Ribble Valley Borough Council
Council Offices
Church Walk,
Clitheroe
Lancashire
BB7 2RA

Phone: 0300 123 6780
Email: Kathryn.Walsh@lancashire.gov.uk
Your ref: 3/2024/0758
Our ref: 3/2024/0758/HDC/KW
Date: 04 December 2024

Location: The Outbarn Clough Bottom Rabbit Lane Talbot Bridge Bashall Eaves
BB7 3NA
Proposal: Application for change of use from a mixed use within Class F1(a) and
a Sui Genris use as a Wedding Venue for up to 40 days a year to a Sui
Generis use as a Wedding Venue for up to 100 days a year
Grid Ref: 370366 443572

Site Plan
(1:1,250)

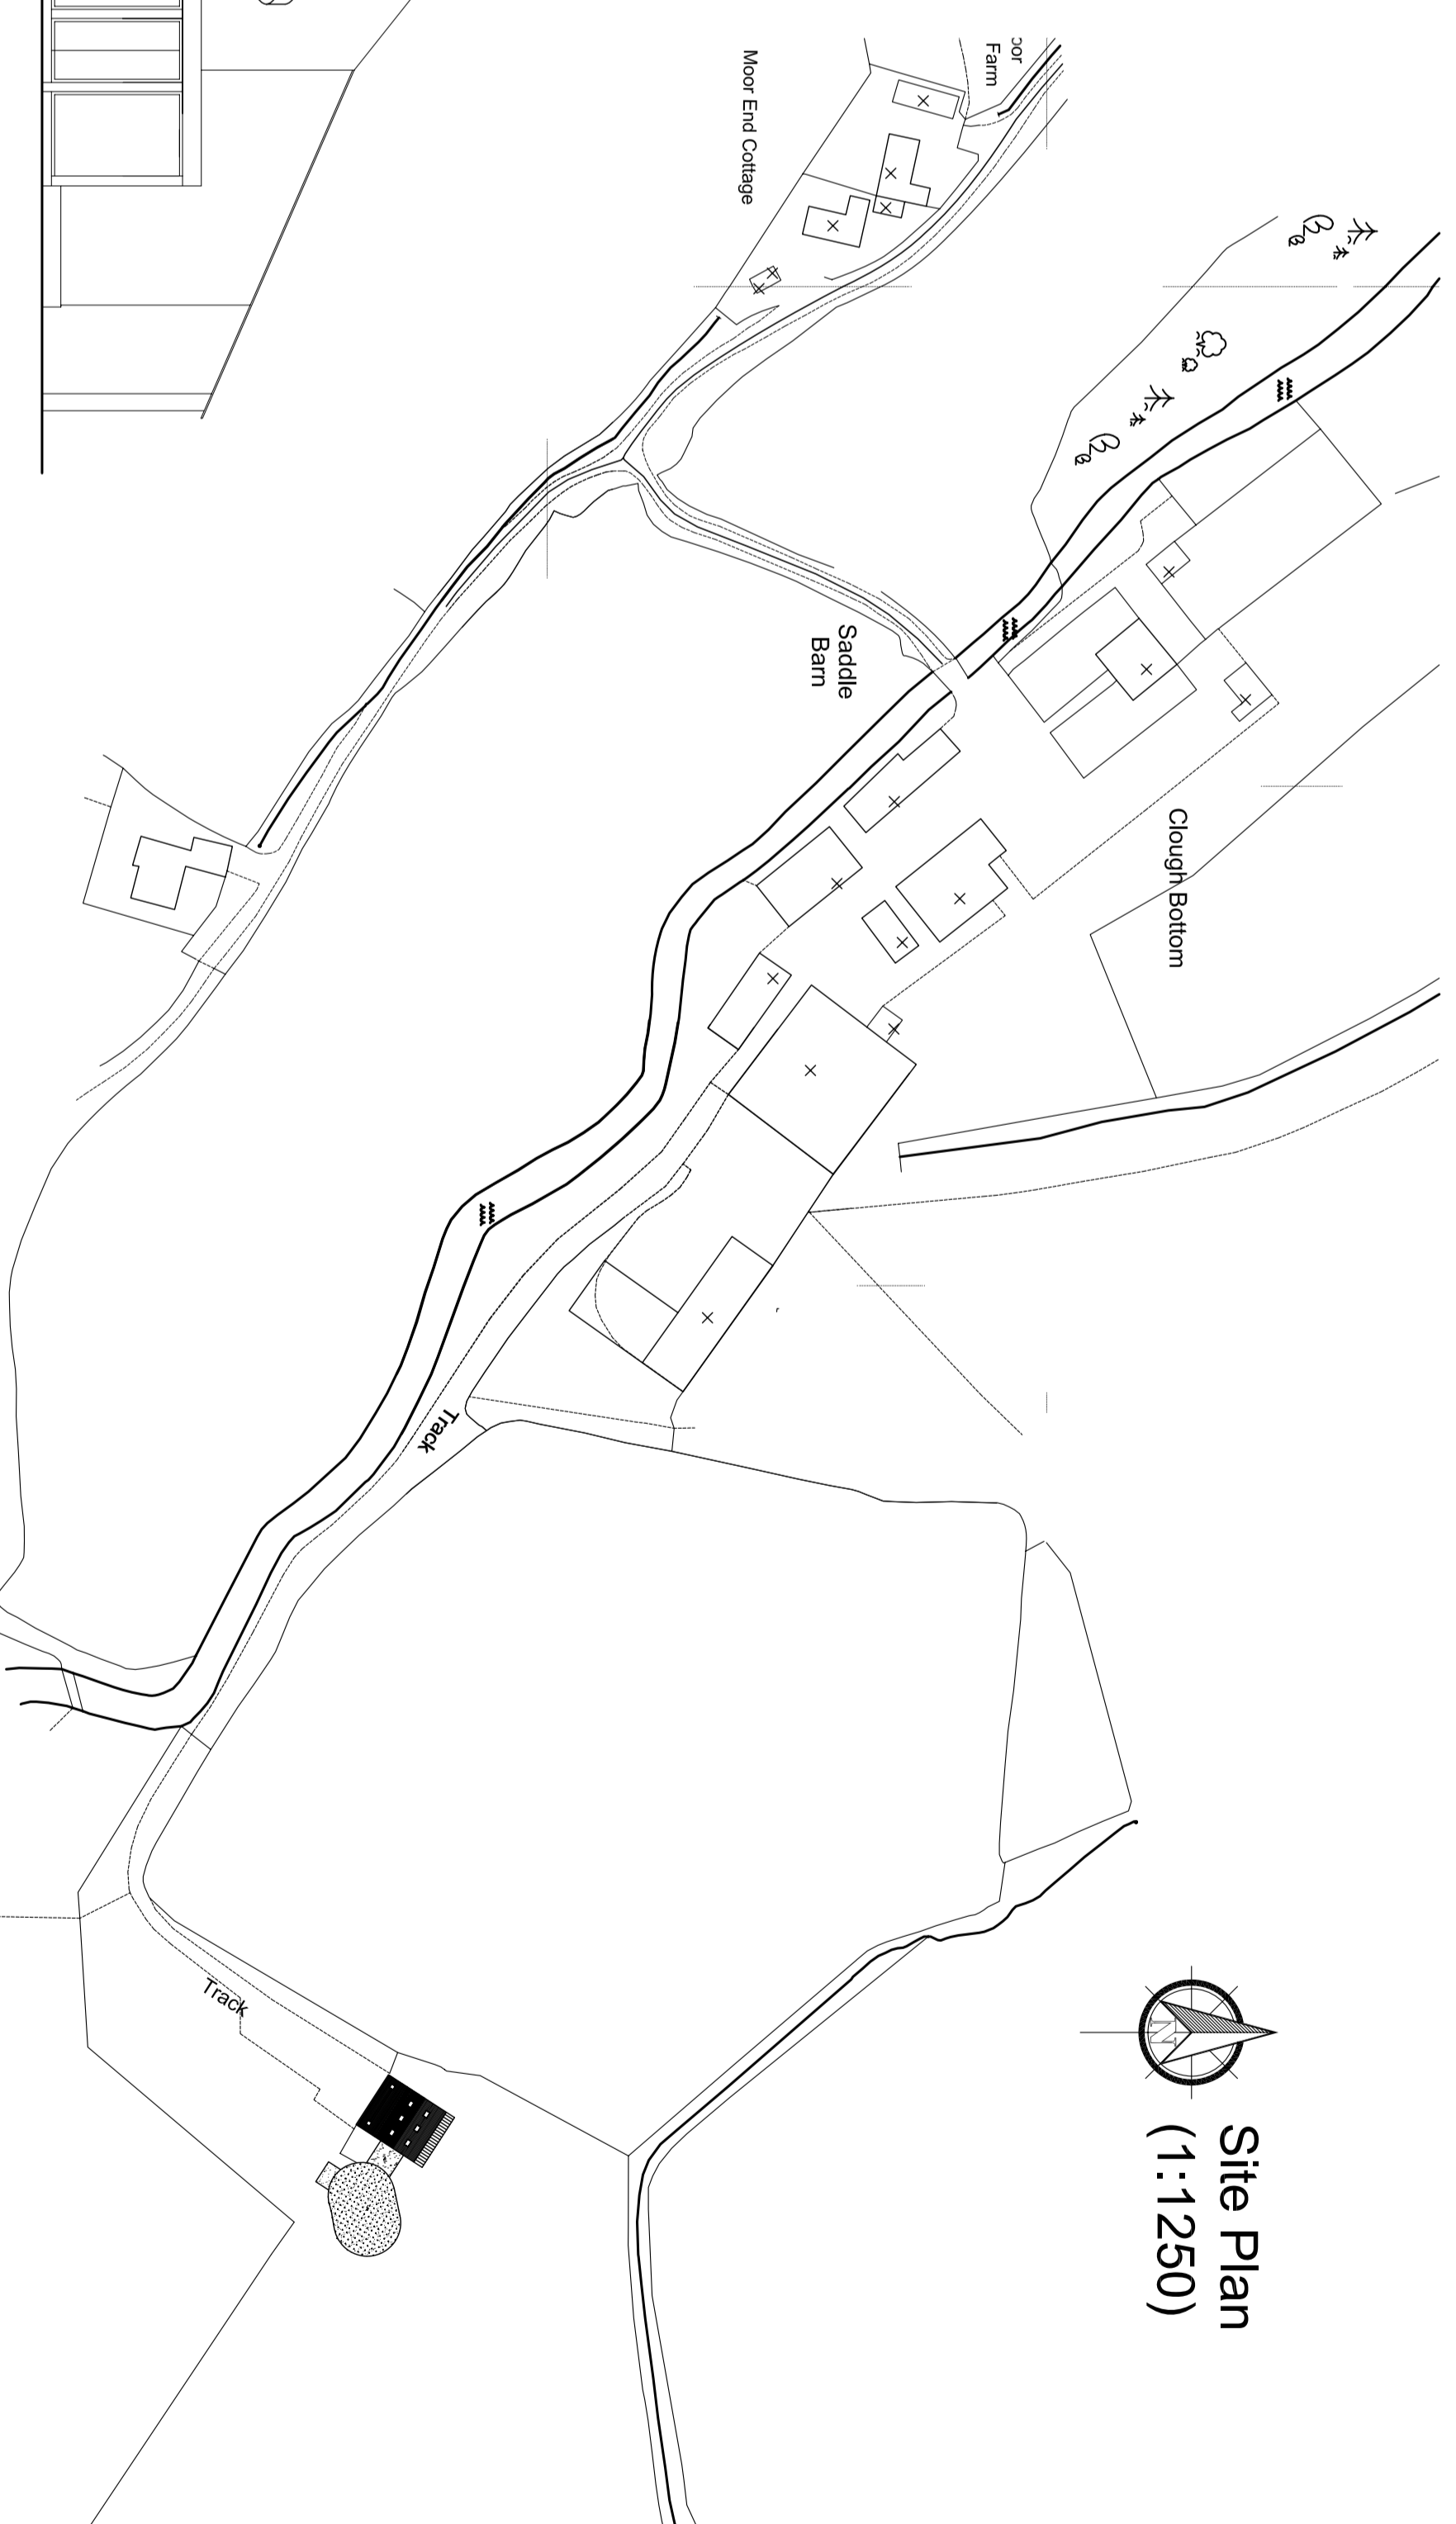
A one-way system was agreed upon as part of planning application 3/2016/0243. However, on-site observation found that the one-way system has not been permanently signed and gates have been erected which discourage vehicle movement along the one-way. Satellite navigation systems also do not follow the one-way, therefore the one-way requires signification improvements for it to be self-enforcing and used appropriately.

The LHA would look for significant improvements through the one-way system to ensure self-enforcement. Improvements may include permanent signage with clear text that has a minimum X-height of 50mm. The applicant should also consider the need for reflective backing which would allow for easy viewing in darkness. While the site is currently meant to have 3 signs in place, no such signs were noted to be in place during a site visit, the LHA would look for improved signage, with the one-way system clearly identified at the entrance point, entering and leaving the parking areas and at any further junction points.

Scaled drawings of the signs to be permanently in place along the internal private road network should be provided, along with a plan indicating the direction of the flow of traffic through the site and the placement of the signs.

The applicant should consider if the one-way system still remains the most suitable and appropriate route through the site. The application should provide an explanation on why the one-way is not being implemented and make alternative suggestions which supports two-way traffic through the site.
